RE: Epping to Thornleigh Third Track Proposal. Application number SSI 5132.

I, Vidia Mikhail of 86 Beecroft Road, Beecroft, NSW 2119 object to the Epping to Thornleigh Third Track Proposal in its current form. There are elements of the EIS that do not address the impact to my residence and community. It will impact on my health and damage the fabric of the Beecroft Cheltenham Heritage Conservation Area. The issues that need to be addressed are;

Figure S.6 Cross-section and elevation - New Cheltenham Station concourse building (see also S.5 for artist's impression)

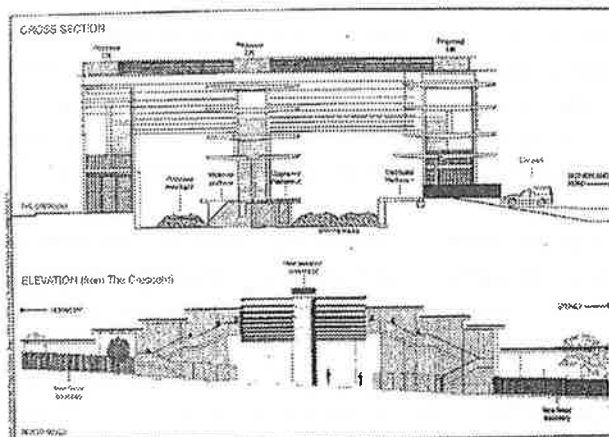
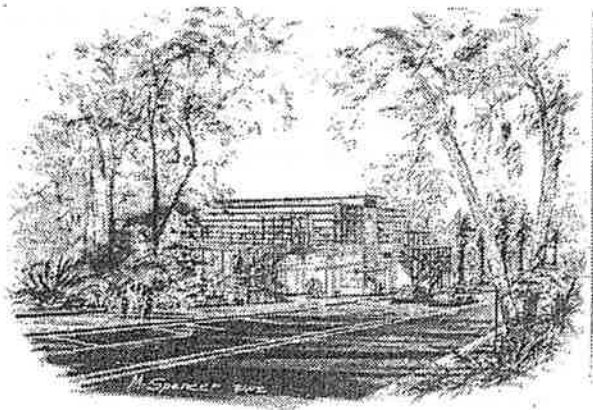
- The proposed redevelopment of Cheltenham Station shows no regard for the HCA. The visual impact of the proposed 13m high glass and steel concourse is totally unacceptable in this HCA.

Figure 5.3 Future Cheltenham Station layout

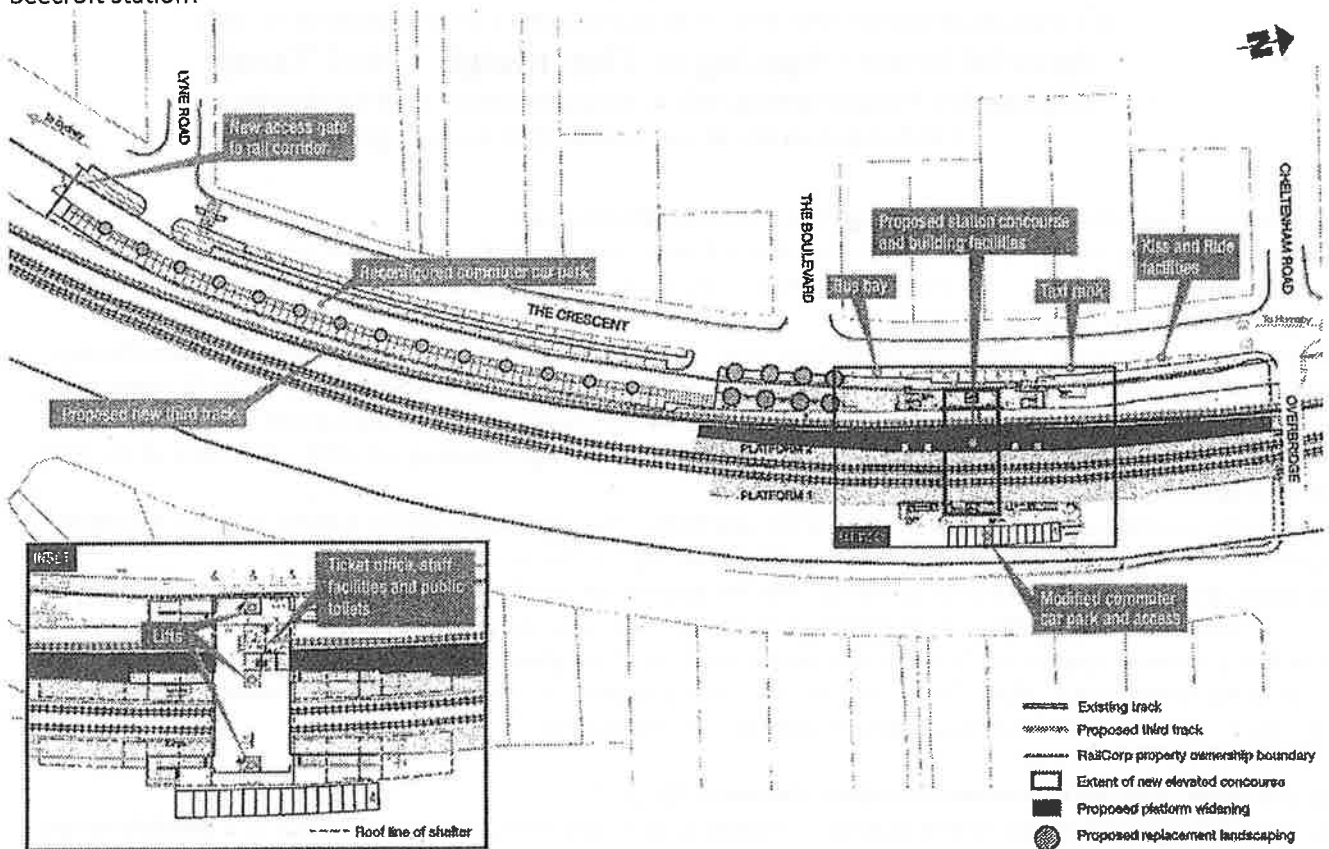
- There has been inadequate assessment of the project's impact on the fabric of the Beecroft Cheltenham Heritage Conservation Area (HCA).
- The plan given for Beecroft Railway station Precinct is vague. The relationship to the trees, playground and original 1895 platform located south of the present station is not shown. A fourth track is shown on the eastern side.
